Application number: 2024/91484	
What is the application for?:	Erection of poultry shed
Address of the site or building:	Bolster Moor Farm, Harden Road, Bolster Moor, Huddersfield, HD7 4JU
Postcode:	HD7 4JU

User comments

HAIGH, PROPOSED POULTRY BUILDING  
AT 33 BOLSTER MOOR FARM,  
GOLCAR, HUDDERSFIELD, HD7 4JU  
FLOOR PLAN AND ELEVATIONS  
1:100 @ A4 MAY 2024

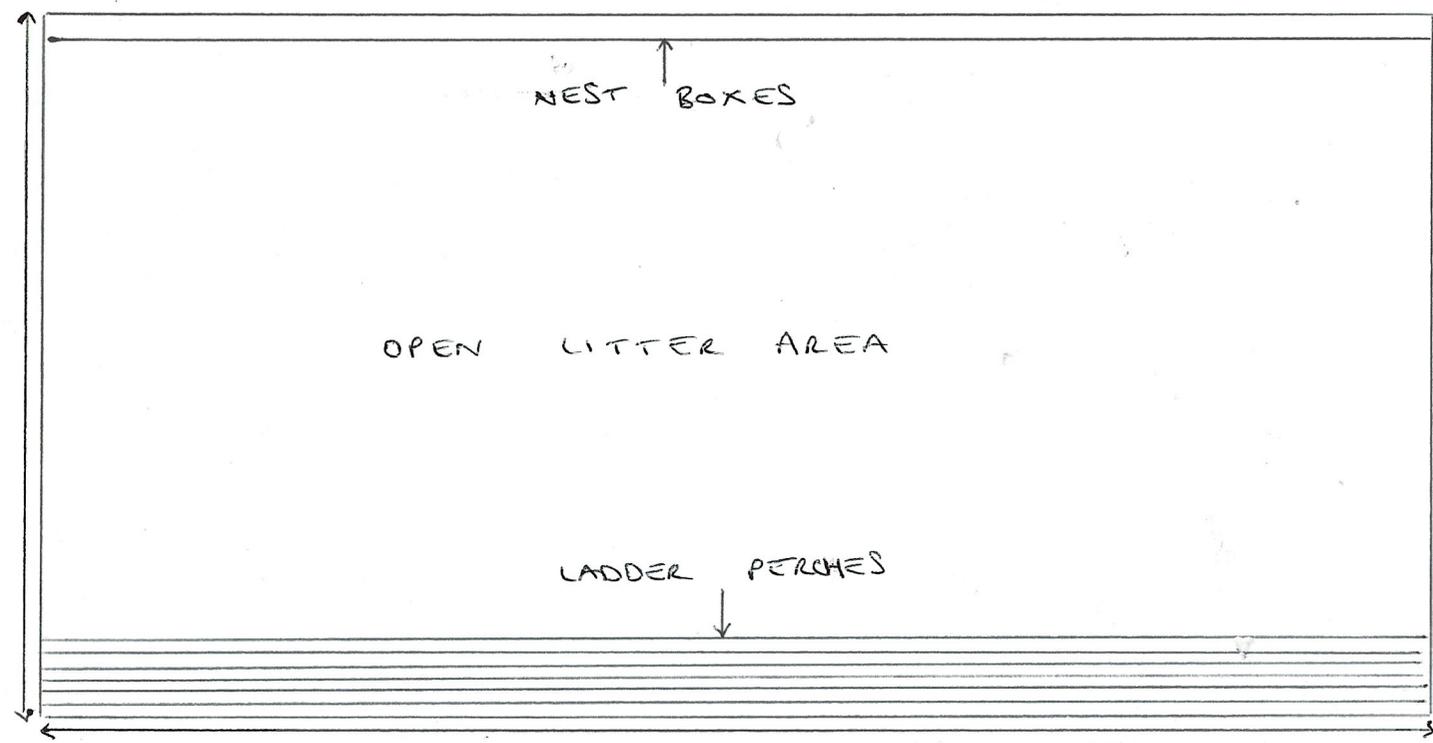
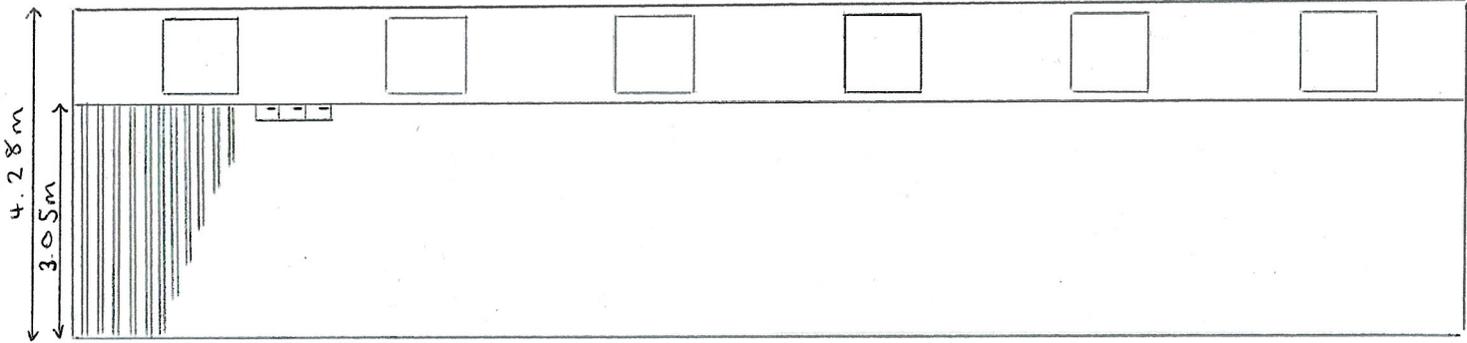
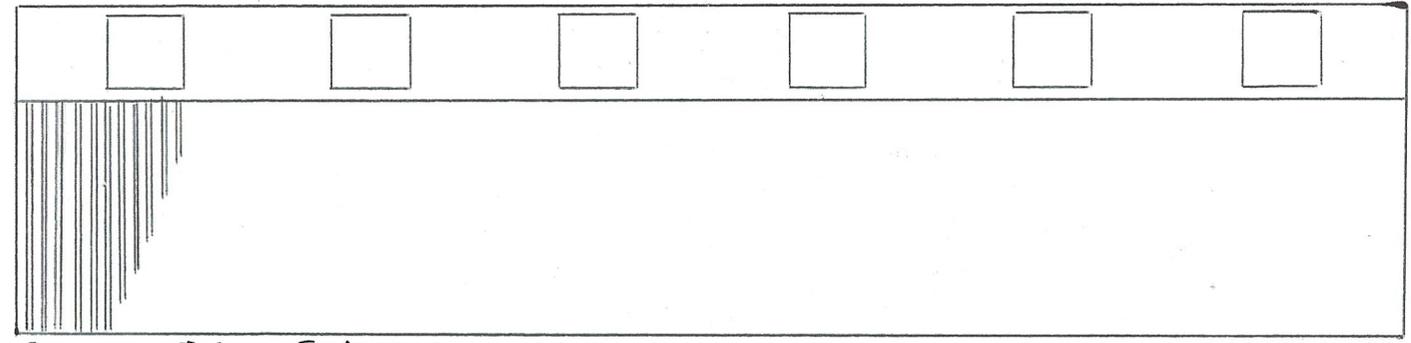
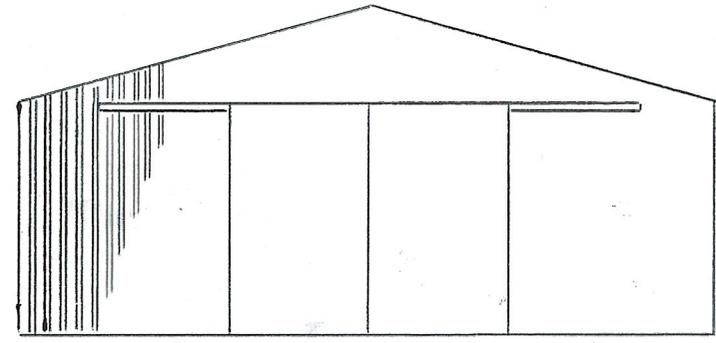
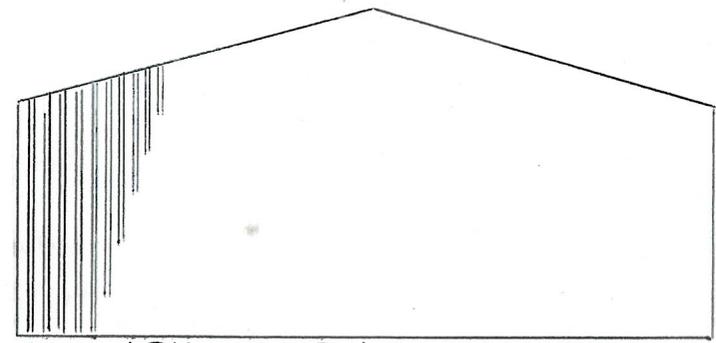
The proposed "muck midden" is less than 10metres from neighbouring properties - making this proposal both disgusting and a clear health hazard. This "midden" area is already used for storing soiled livestock bedding, general waste and various types of excrement which, in times of prolonged, heavy rain already creates effluent runoff which flows through and across neighbouring properties before entering the roadside drains on Bolster Moor Road.
